Your ref:
Our ref: 23/00804/CU
Please ask for: Miss Joanne Wren
Direct dial: 01553 616233
E-mail: borough.planning@west-norfolk.gov.uk

9 May 2023

Details: **Change of use from children's day nursery to residential dwelling. The property was originally a 6 bed house with attached 3 bed annex and it is proposed to return it to this at Martins Place 93 Main Street Hockwold cum Wilton Thetford Norfolk**

Ground Floor  
Scale 1:100

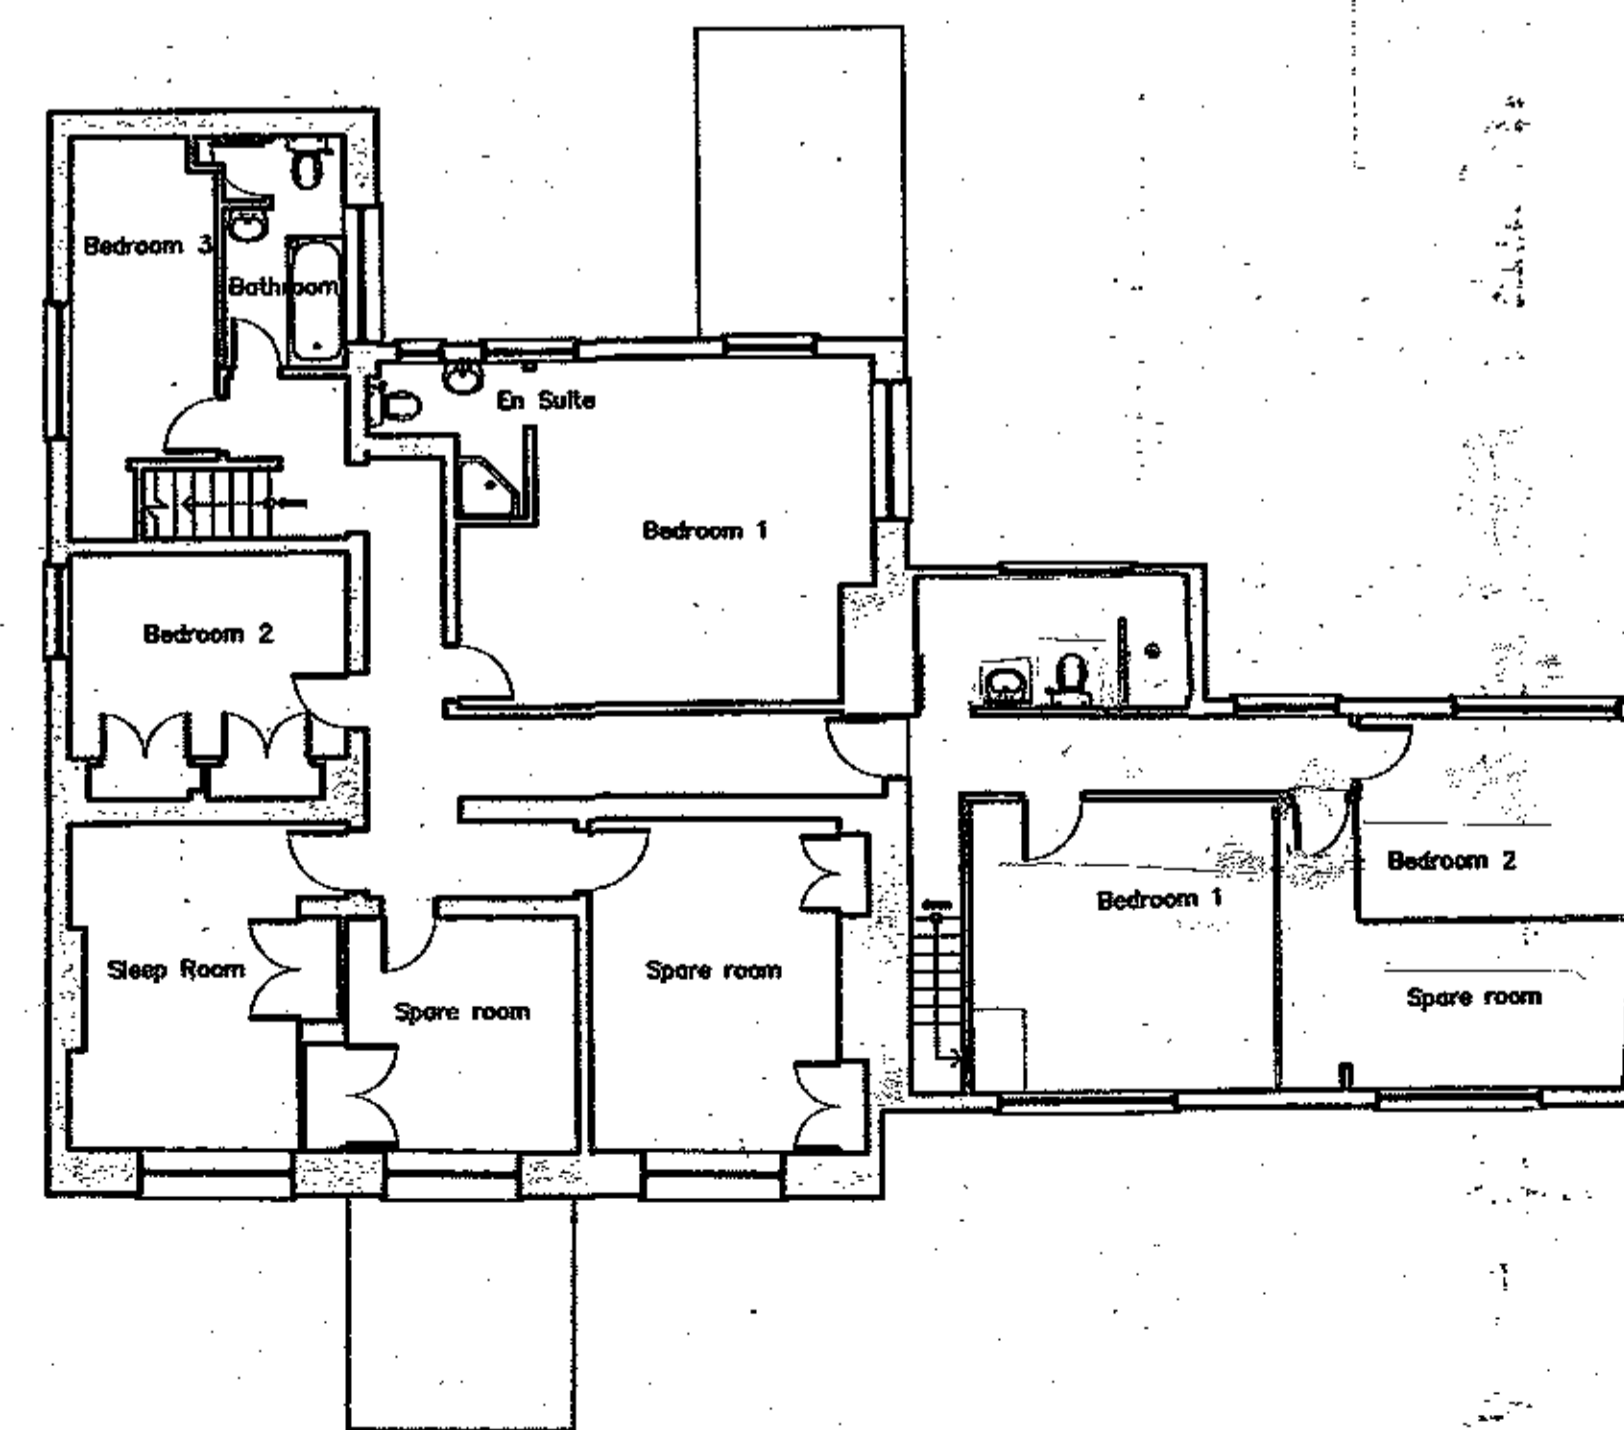
2. Thank you for your floor plans but these are not labelled. Please submit two sets of floor plans, one labelled as existing and one labelled as proposed. These should be done to a scale of 1:50 or 1:100.
3. Can you please submit a location plan. A location plan identifies the land to which the application relates drawn to an identified scale and showing the direction of North. The site should be edged in red and any other adjoining land owned or controlled by the applicant edged in blue. Location plans should be to a scale of either 1:1250 or 1:2500.
